# CITY OF ALBUQUERQUE

## OFFICIAL NOTIFICATION OF DECISION

**Project # 1009204**  
12EPC-40015 Site Development Plan for  
Building Permit  
12EPC-40018 Amendment to Zone Map (Zone  
Change)

For the northerly portion of Lot 33, Alvarado Gardens, Unit 1, located on Rio Grande Boulevard NW between Contreras Place & Matthew Avenue containing approximately 1.2 acres.  
Randall Falkner, Staff Planner

BUILDING ELEVATIONS
SITE DEVELOPMENT PLAN FOR BUILDING PERMIT
RIO GRANDE HOUSING
2334 RIO GRANDE BLVD

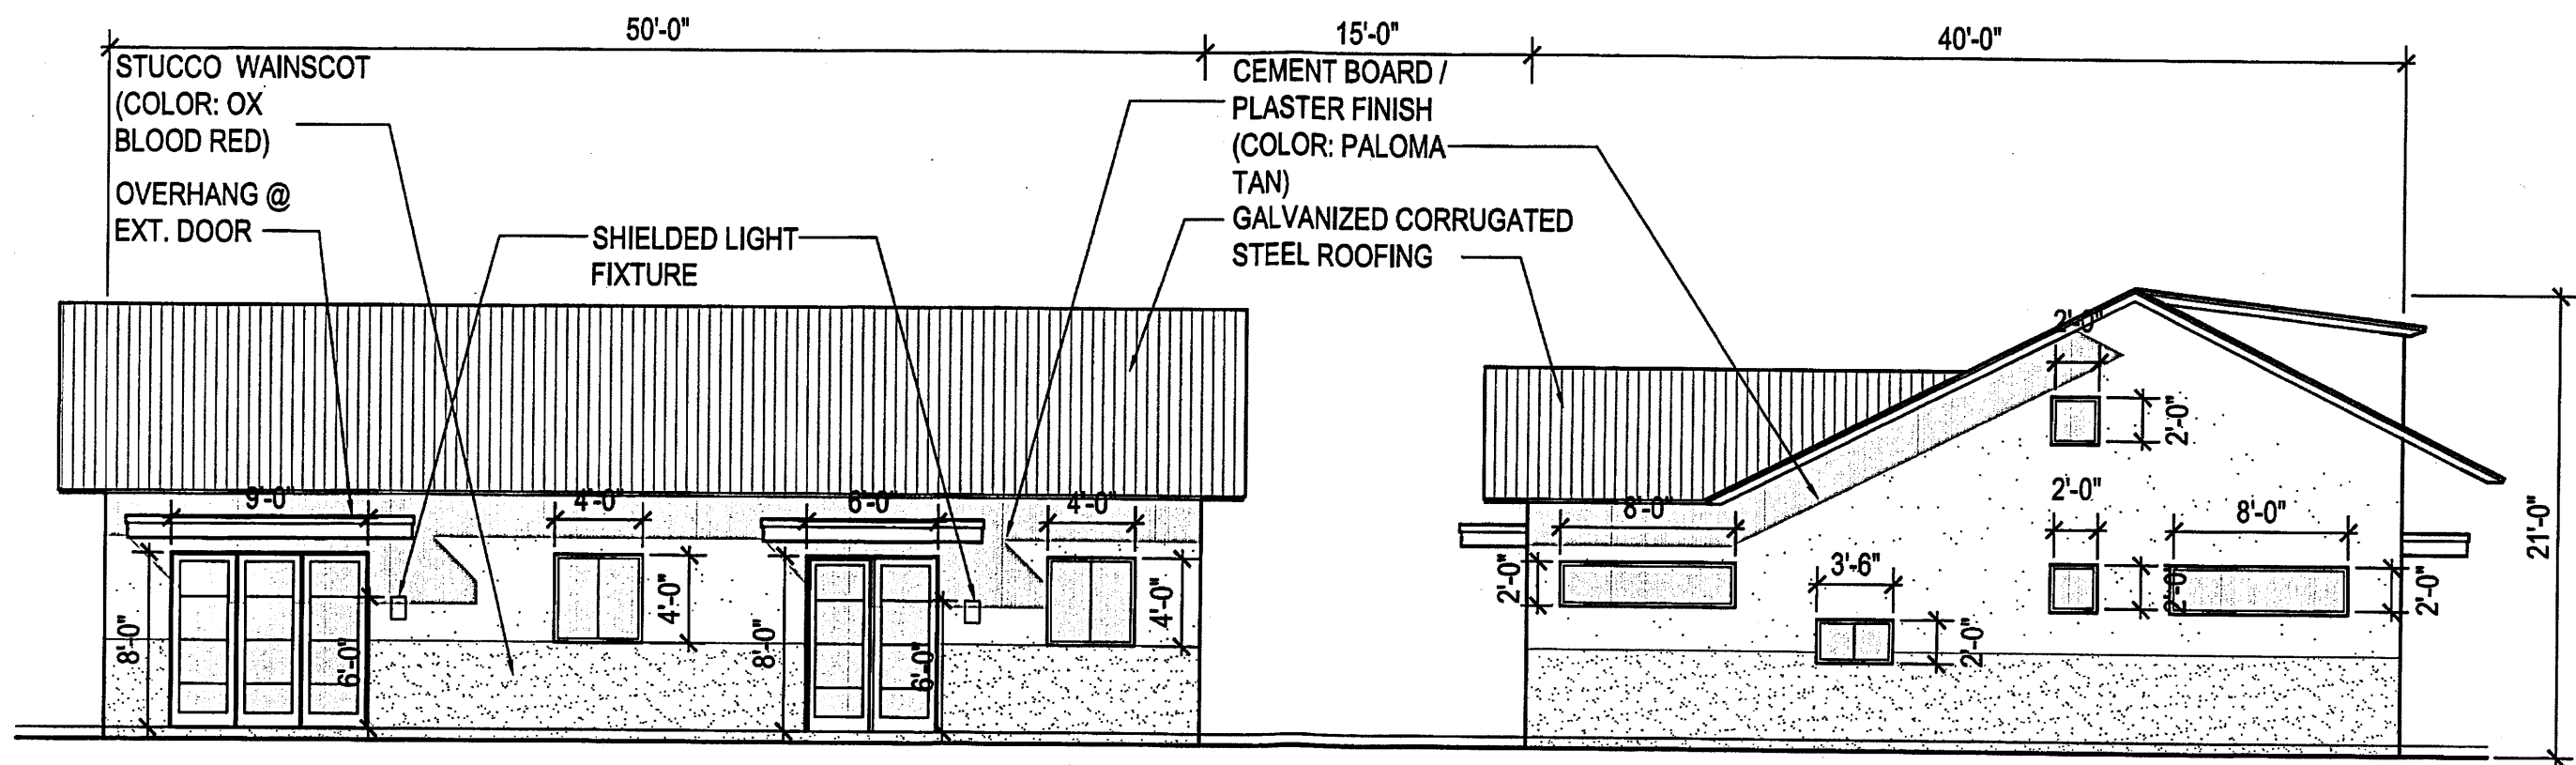
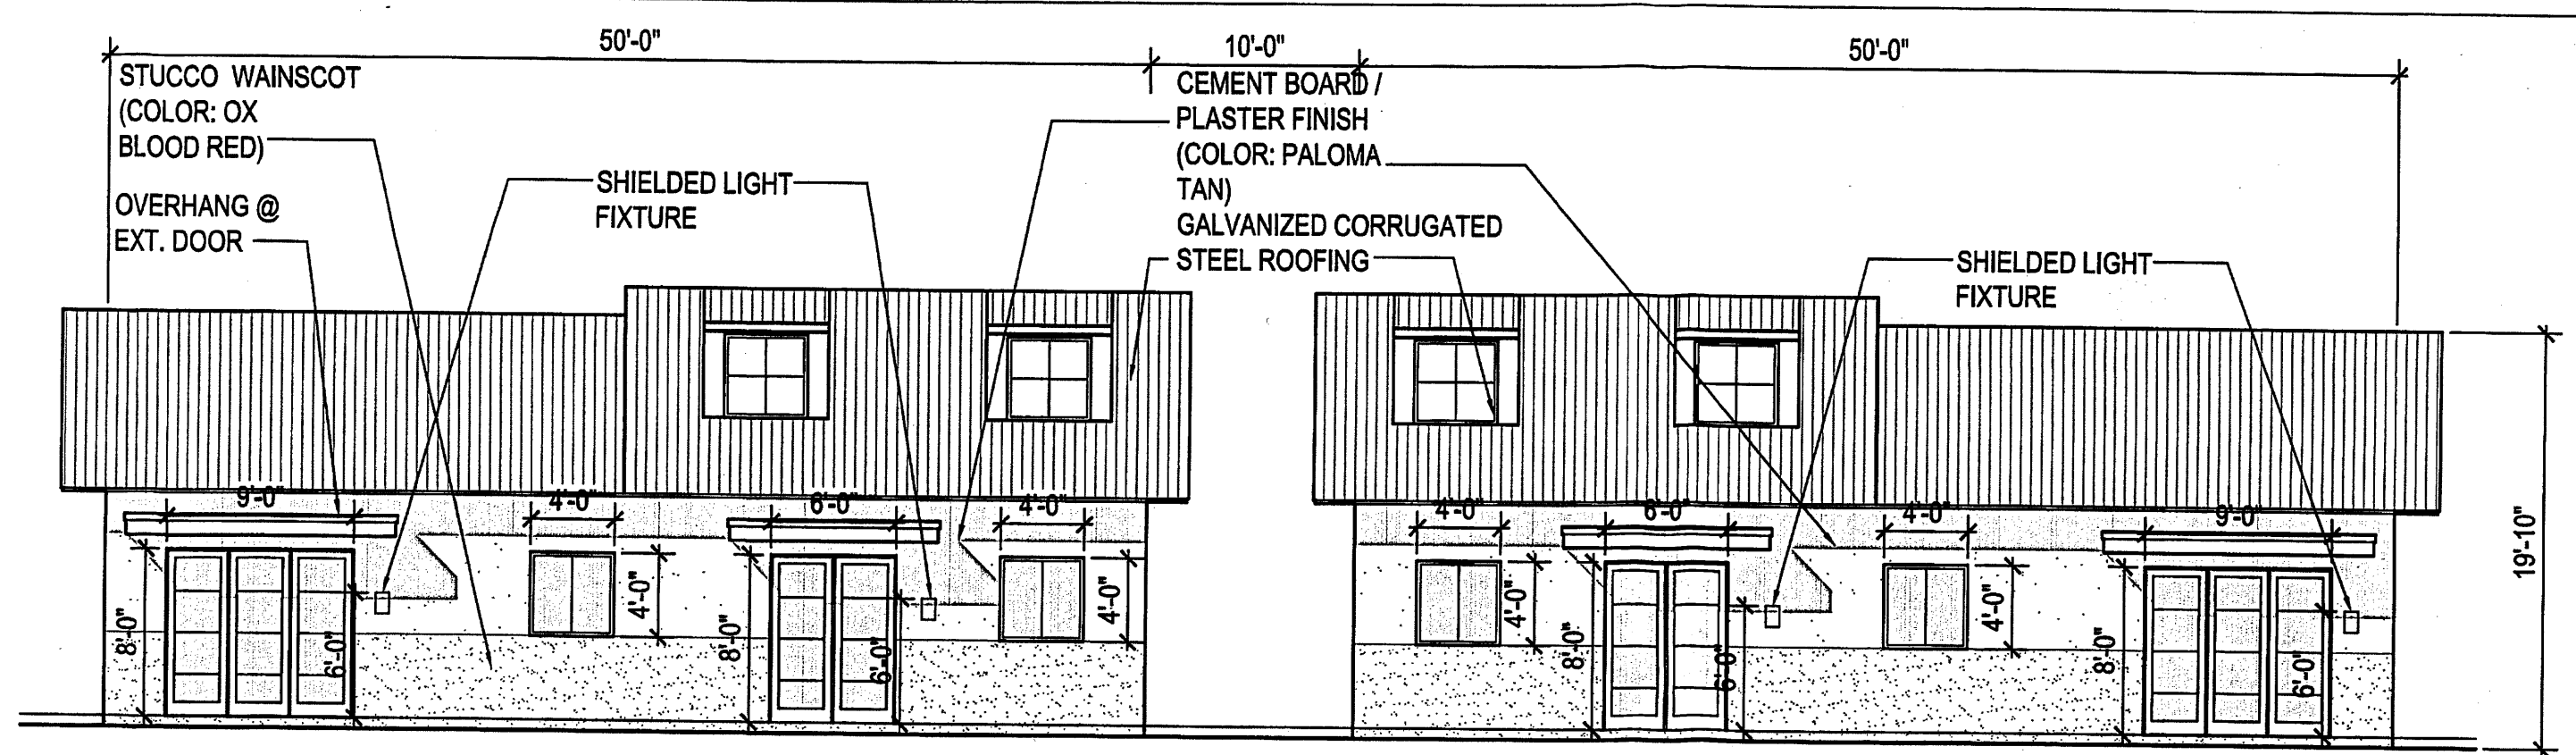
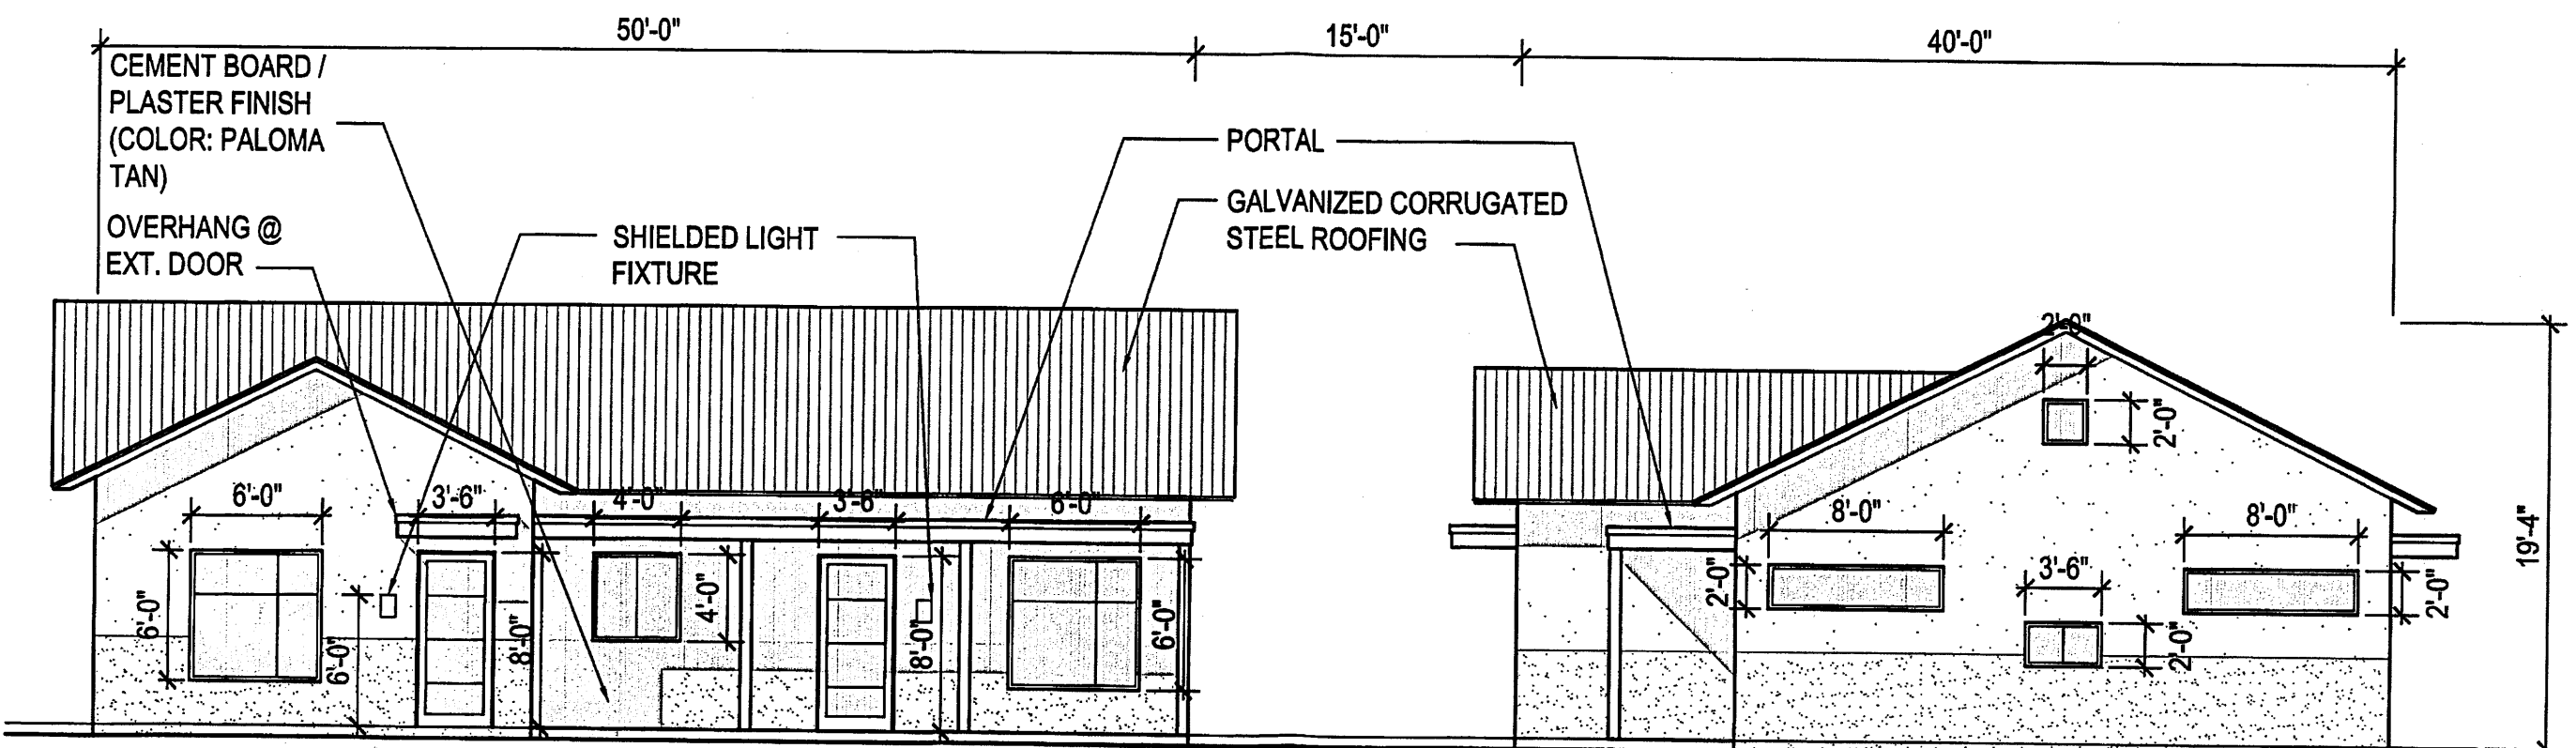
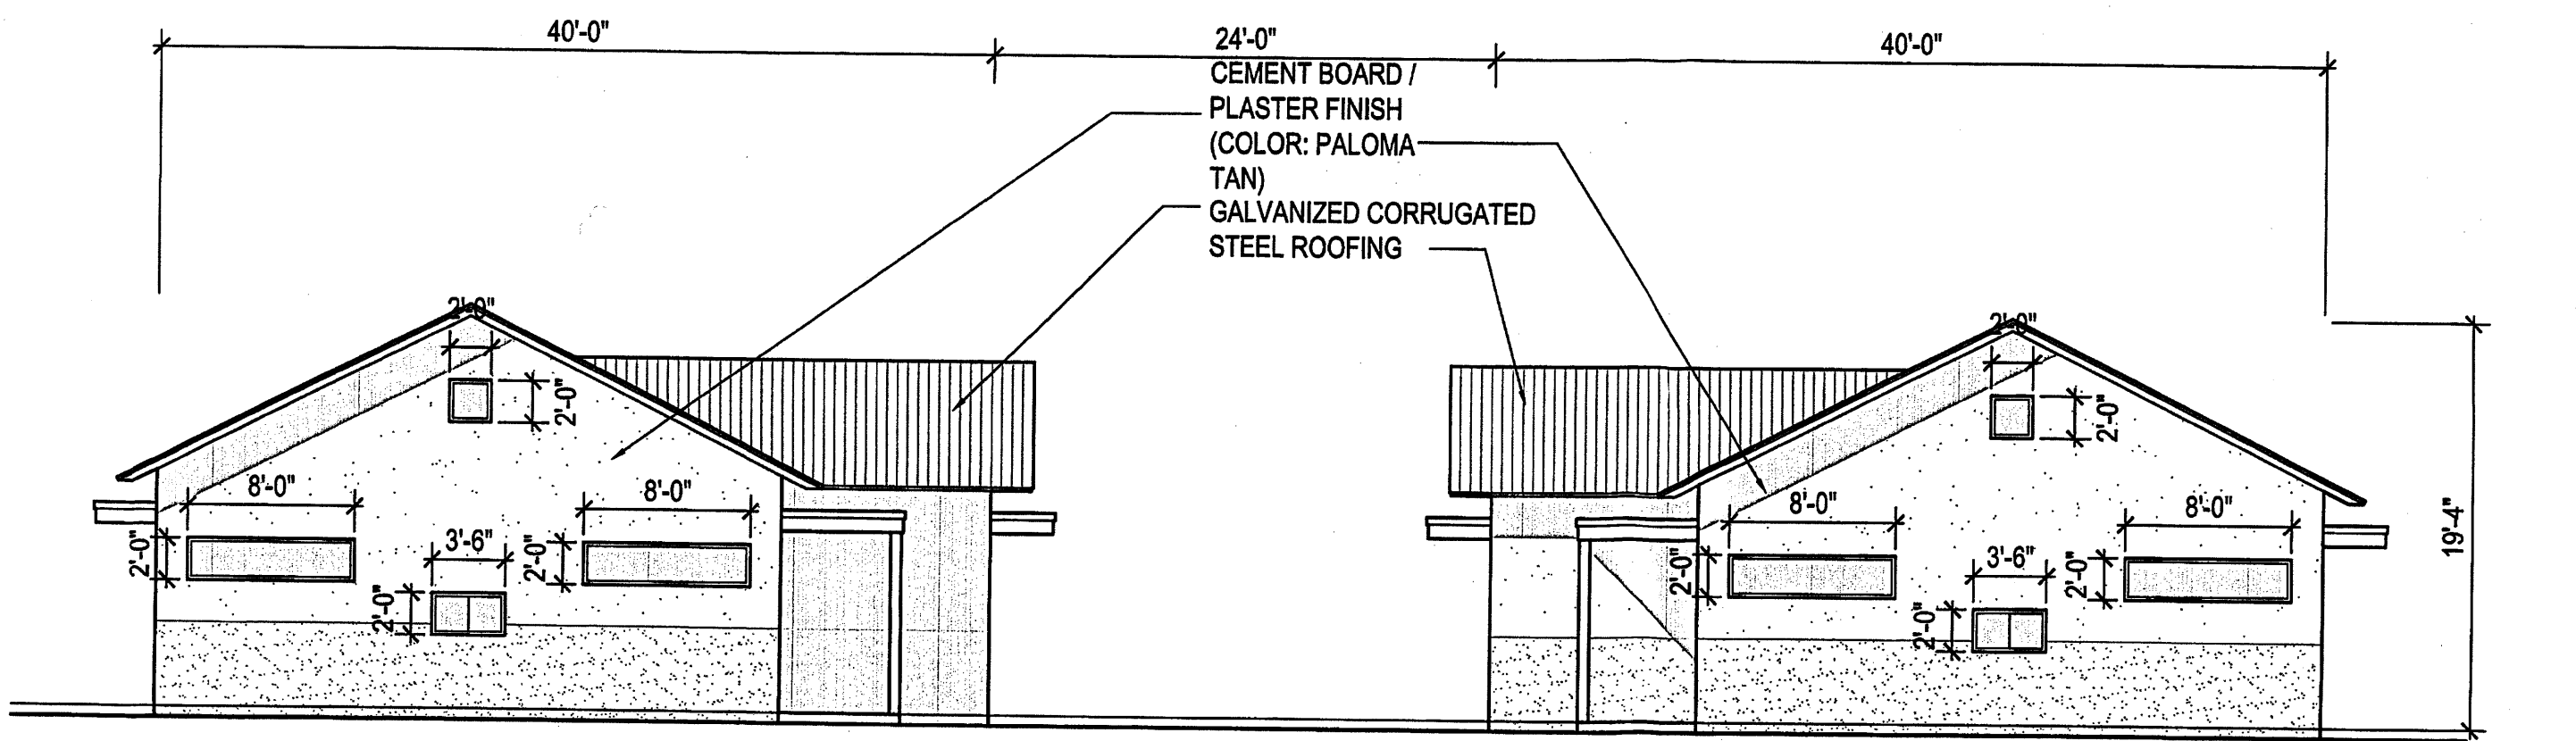
12. The height of the buildings at the top of the pitch shall be a maximum of 24 feet.
13. The EPC supports a variance to the entrance width in order to maintain the existing width of 25 feet.
